23 September 2014

KEH/CRB/sep/1126

Re: **Proposed Conversion of Existing Barn into Habitable
One Bedroom Cottage Accommodation – Sack Lane, Lidsey**

In accordance with your instructions received through our mutual client, Mr. J. Langmead, I did on Thursday, 18th September 2014 attend the above site and carried out a survey and inspection of the existing barn with regard to its structural capabilities for the proposed conversion to a habitable dwelling, all as generally indicated on your architectural drawing nos. 2014/04/01-03 inclusive.

West Elevation

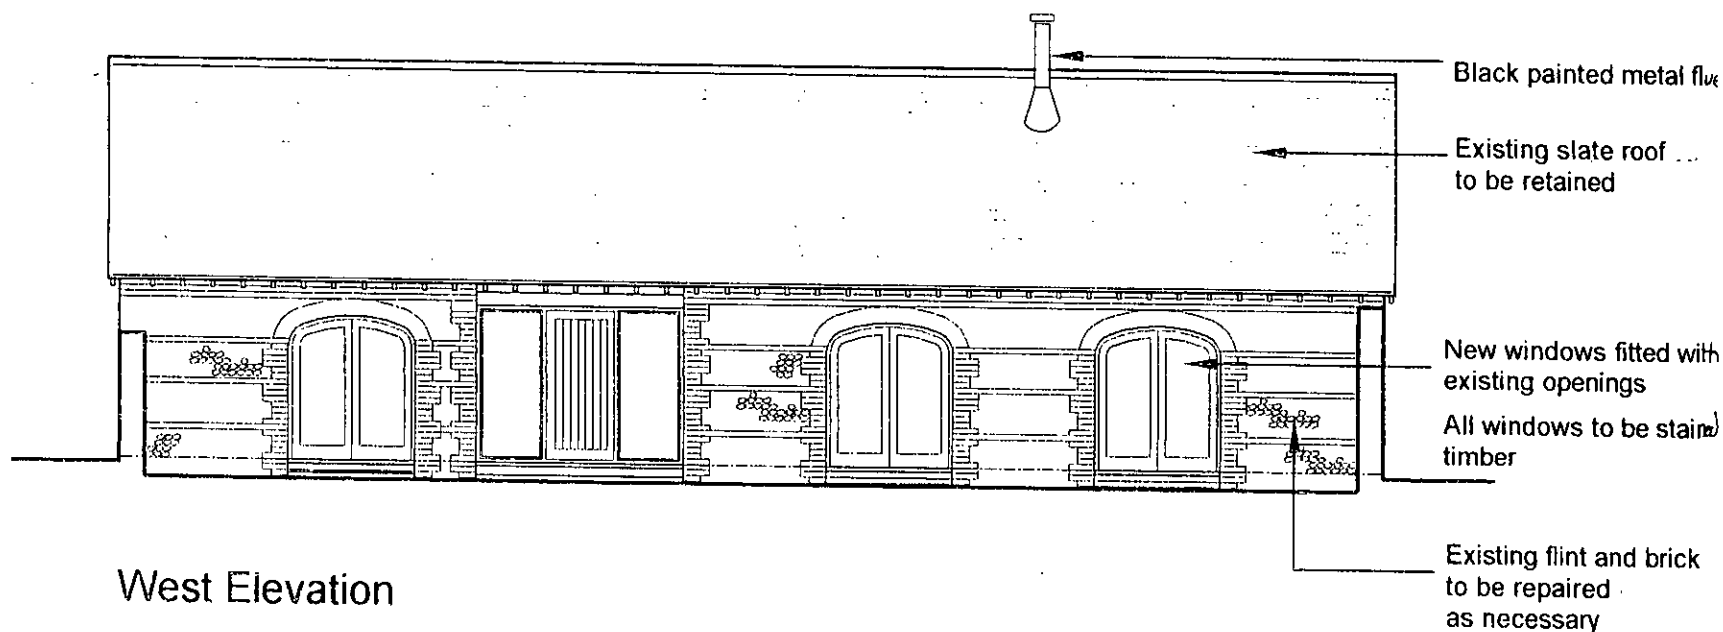
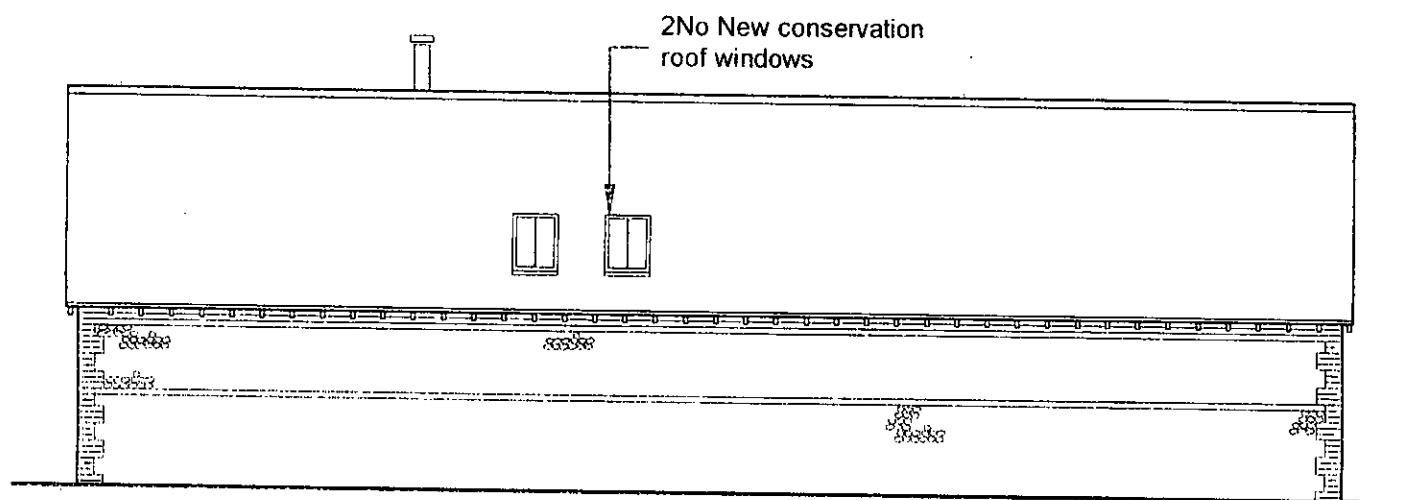
There are three existing large openings in the west elevation, two of which have feature brick arches over. All details are as generally indicated on the aforementioned architect's drawings. We are respectfully informed that this building is not Listed.

Externally, there was some evidence of mortar fatigue, particularly around the feature brickwork to the existing main openings.

5. The existing timber pitched roof construction should receive additional horizontal ties at approximately 2M centres fixed across the existing rafters at approximately mid height position.
6. New insulation should be fixed between and over the existing ceiling joists to architect's specification and to achieve the required 'U' value.
7. New window openings should have new precast concrete lintels over to support existing masonry. The new brick arch opening should be constructed to match the existing.
8. Externally, the masonry walling and flint work may require repointing and repair in some isolated areas.

Section

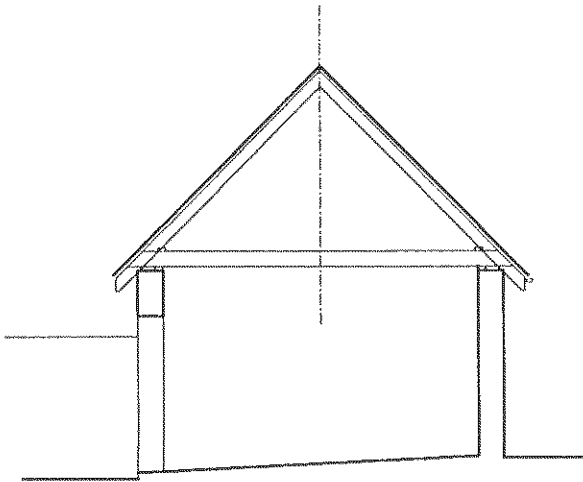
The existing pitched roof construction consists of a slate covering on timber battens on roofing felt on pitched rafters at 400 centres supported on wall plates and ceiling joists with noggins in mid span. Diagonal timber bracing has also been incorporated within the roof plane of the rafters.

The wall plate construction has been suitably strapped down to the inside face of the existing masonry walls with galvanised mild steel straps.

Floor Plan

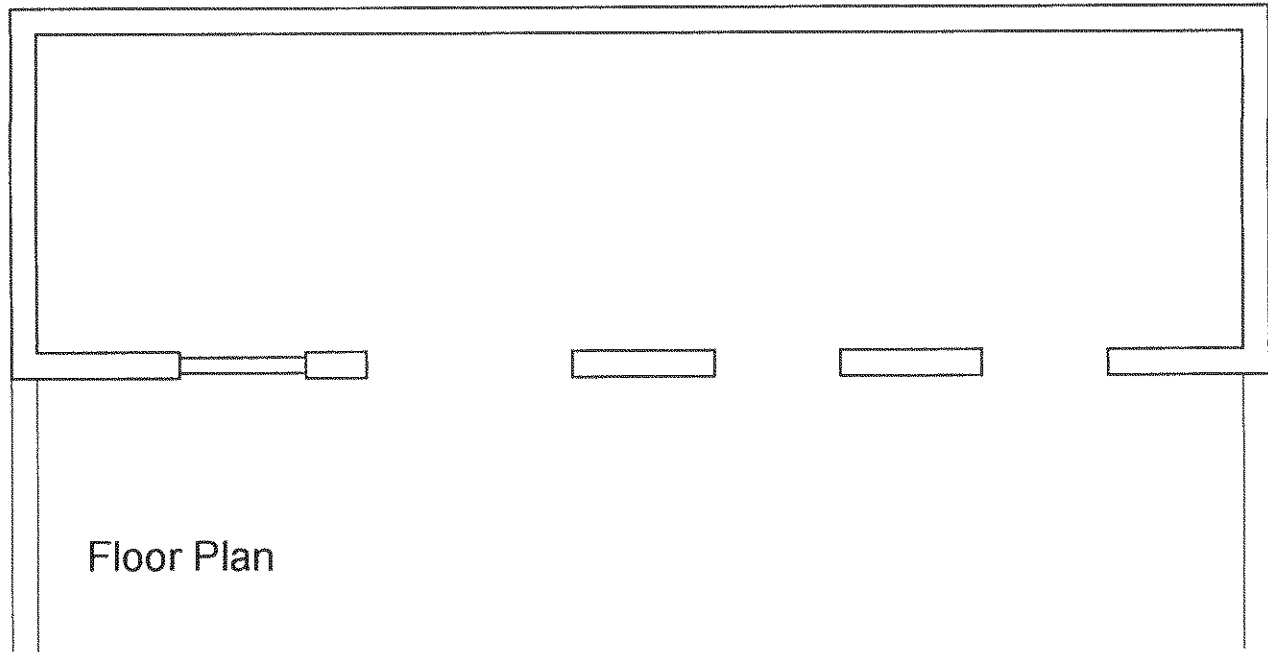
The existing ground floor was of compacted earth approximately level with the external ground level. This will require reducing to support a new ground floor slab construction.

1. The vegetation growth which exists around all elevations should be completely removed.
2. The existing ground floor area internally of the building should be reduced in level to allow the construction of a new ground floor slab arrangement consisting of a minimum of 150mm hard core base with 1200 gauge polythene dpm membrane over turned up the inside face of the existing masonry walls. This to receive a new minimum 150mm thick concrete ground floor slab with thickened toes around the internal perimeter to support the new internal timber stud work. The slab should be reinforced with one layer of A393 mesh reinforcement. The slab to receive insulation and screeded finish to architect's specification and achieve the required 'U' value. Non load bearing internal timber or block partition walling may be constructed directly off the reinforced concrete slab.

The new finished ground floor level should be at least 150mm above the external ground level.

3. The internal masonry walls should receive three coats of 'Synthaproof' up to a minimum height of 600mm above floor level.
4. Internally around the perimeter of the existing masonry walls and built off the thickened reinforced concrete slab an internal stud wall should be constructed with sole and header plates and noggins in mid height. The stud work should be suitably insulated and finished to architect's specification and to conform with 'U' value requirements.
